Application no: **3/2023/1051**

Address: **24 Waddow Grove Waddington BB7 3JL**

Proposal: **Two storey extension to side and rear to include two rear dormers following demolition of existing extension, rooflights to side elevation and internal reconfiguration to residential property.**

The Local Highway Authority have viewed the plans and highway related documents and have the following comments to make:

name **Proposed Site and Roof Plan**

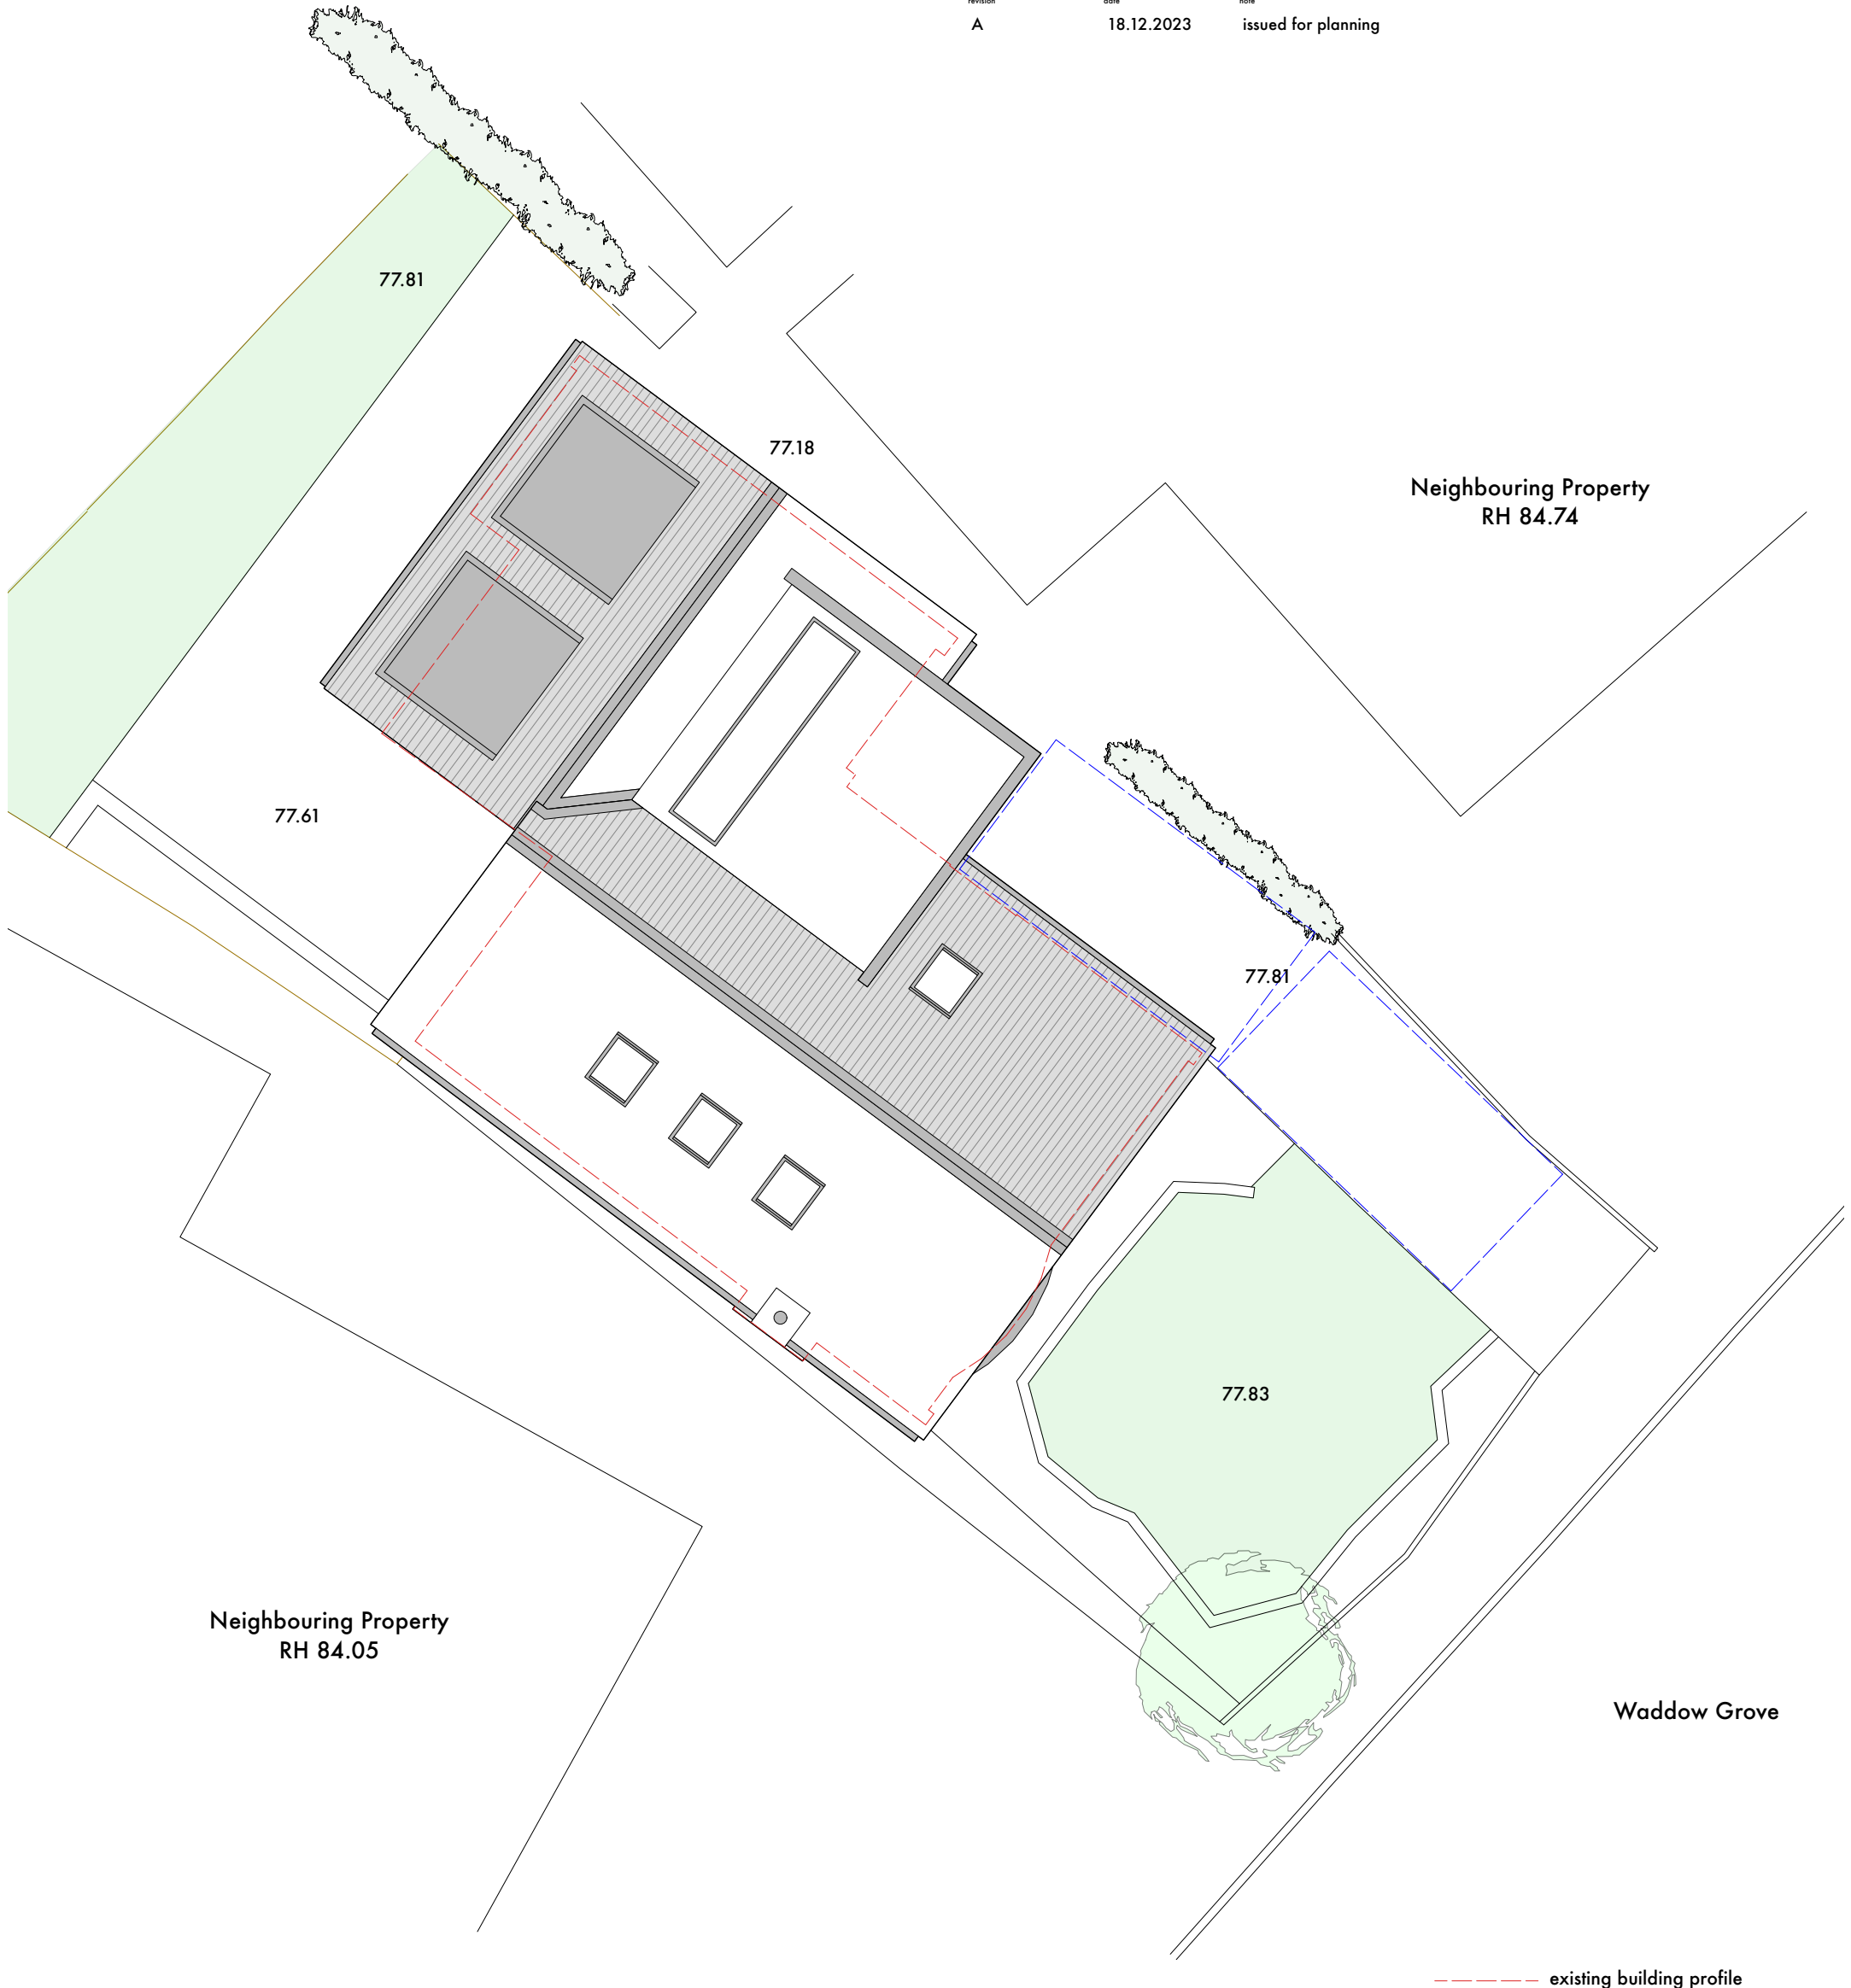
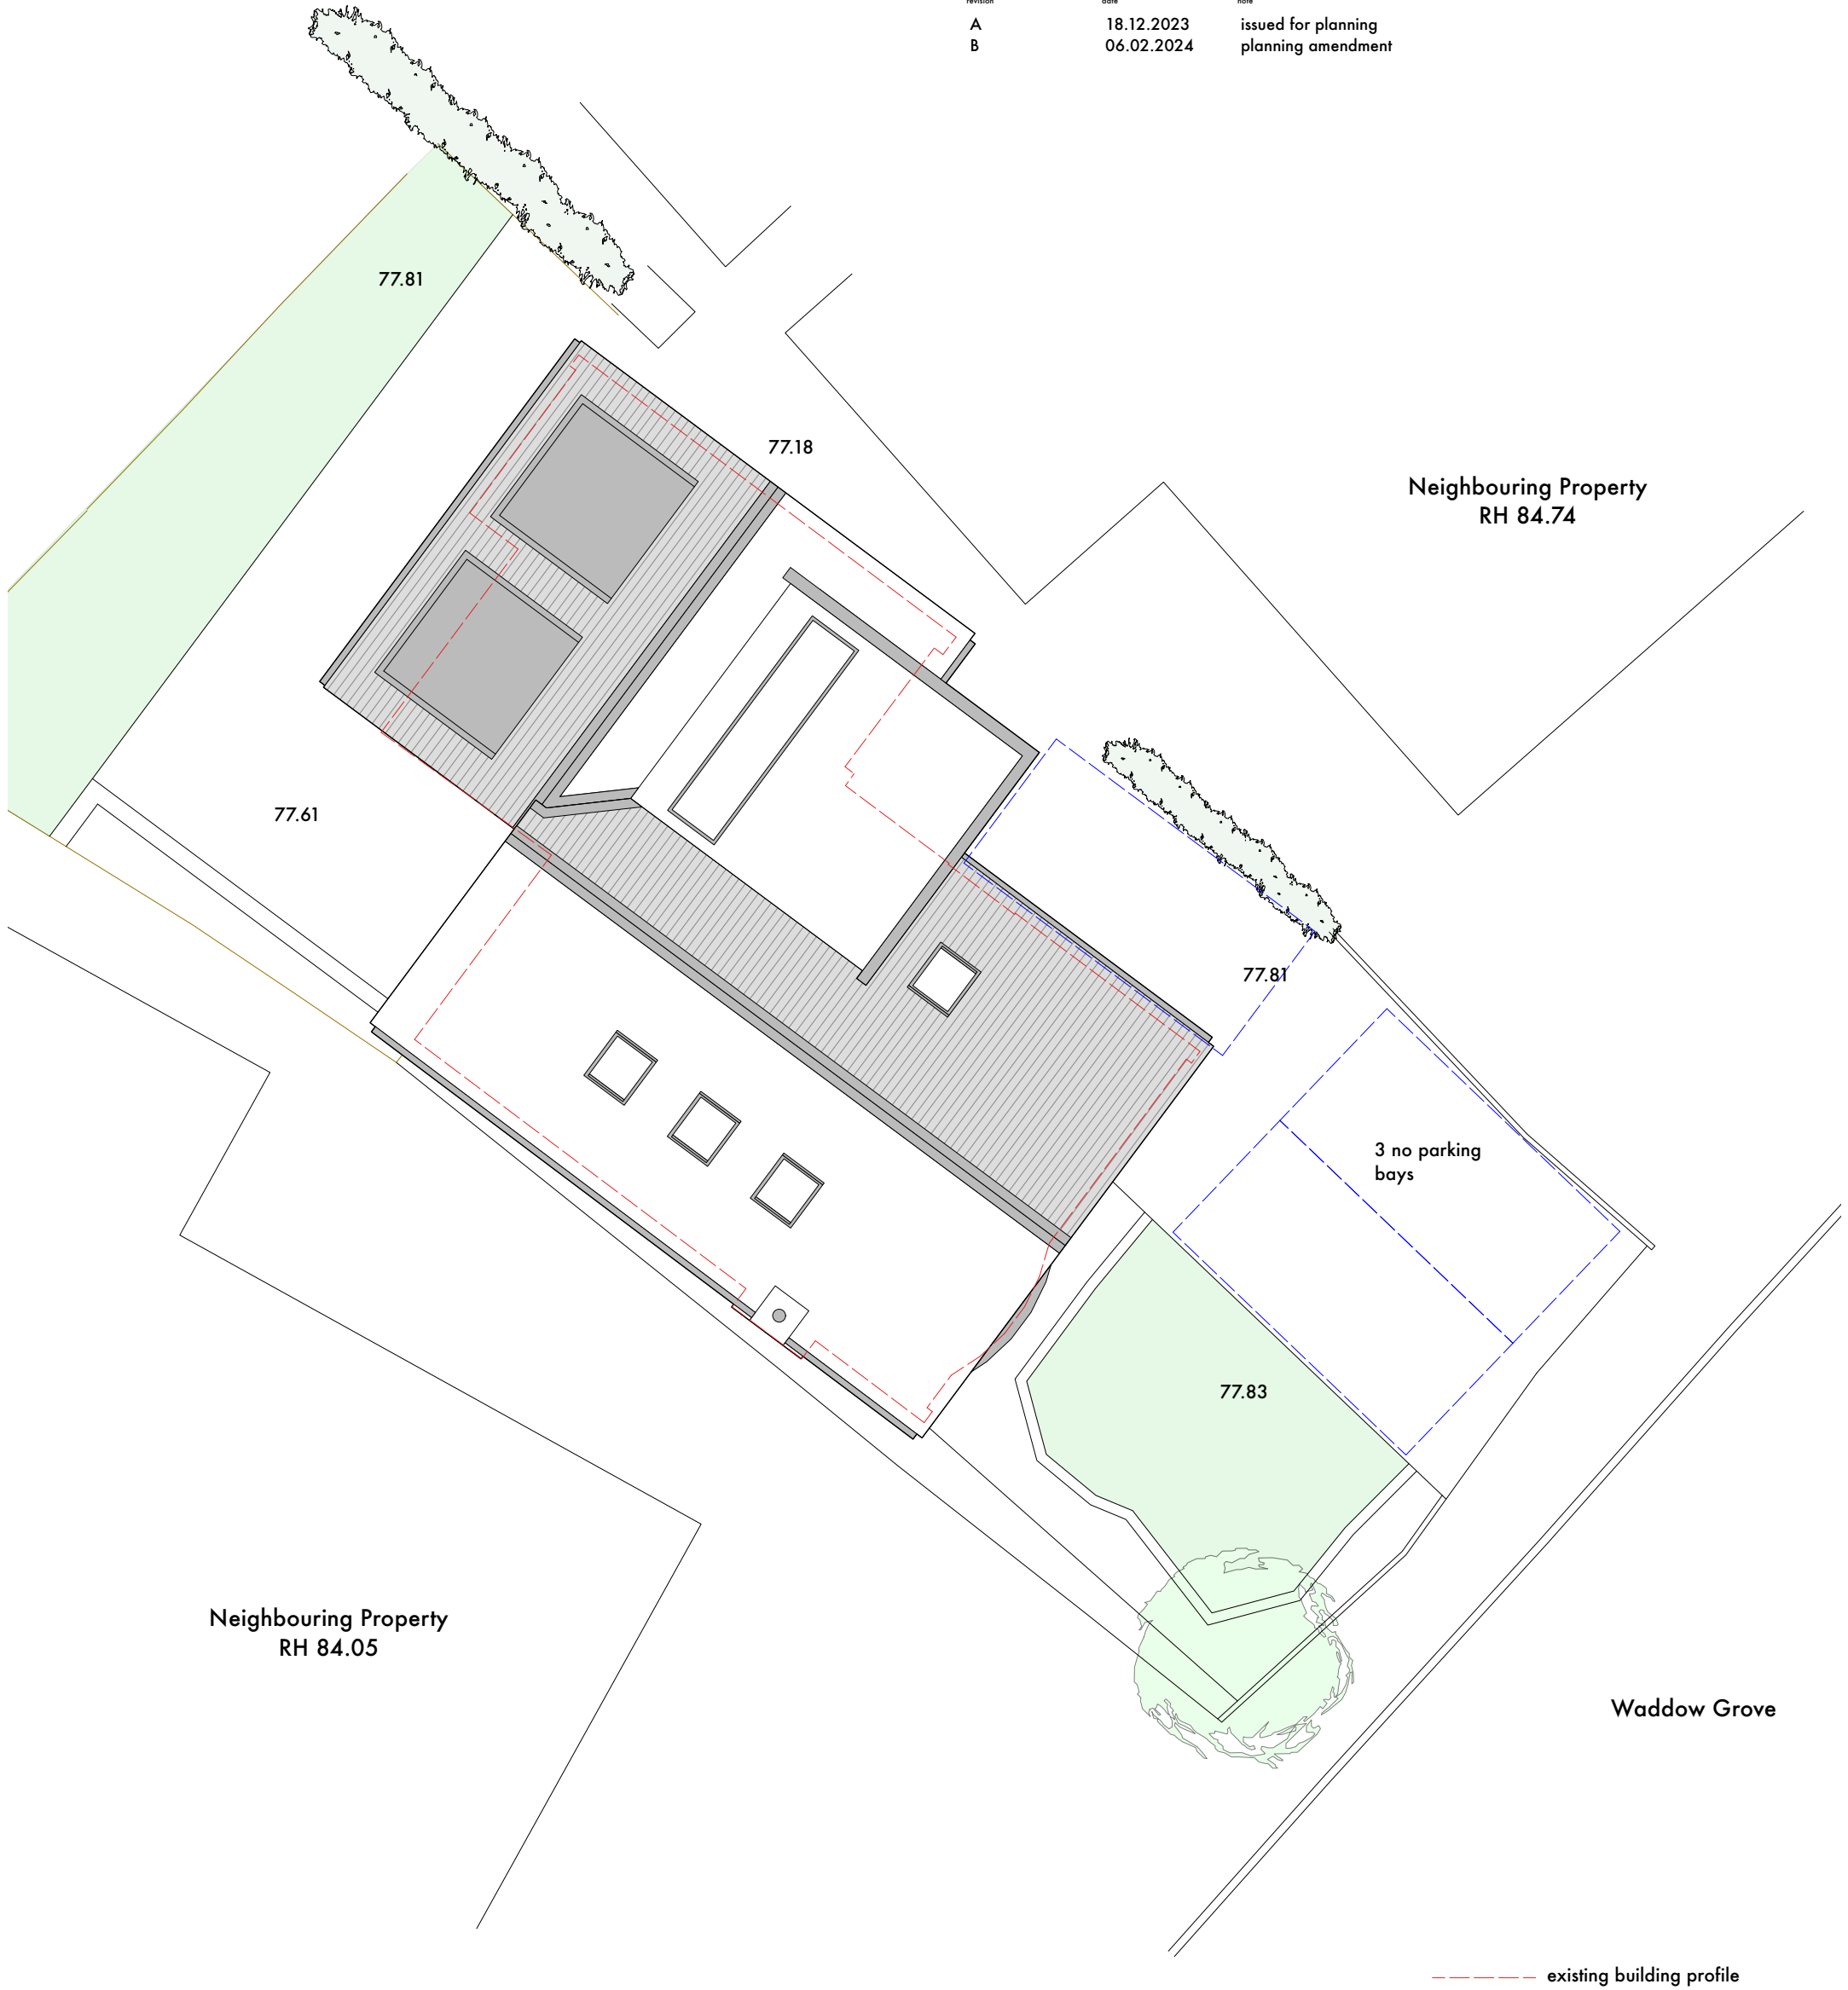
The LHA have reviewed Stanton Andrews drawing number PL01 Rev A titled "Proposed Site and Roof Plan" and are aware that the dwelling can provide 2 car parking spaces for the proposed 4+ bed dwelling. This does not comply with the LHAs parking guidance as defined within the Joint Lancashire Structure Plan, which requires a 4+ bed dwelling to provide 3 car parking spaces. As a result, the LHA require a revised parking plan to be submitted showing that the site can provide a minimum of 3 spaces.

The LHA require that the parking guidance is complied with because the dwelling is opposite the turning area for Waddow Grove. Therefore, the LHA do not want to allow any inappropriate parking on the adopted highway which could compromise the use of the turning area for large vehicles.

The LHA advise that the access and the driveway is extended by a further 2.4m which will incorporate a part of the adjacent grassed area. This should be shown on a revised parking plan and the LHA inform the Applicant that any extension to a dropped kerb will need separate consent from Lancashire County Council.
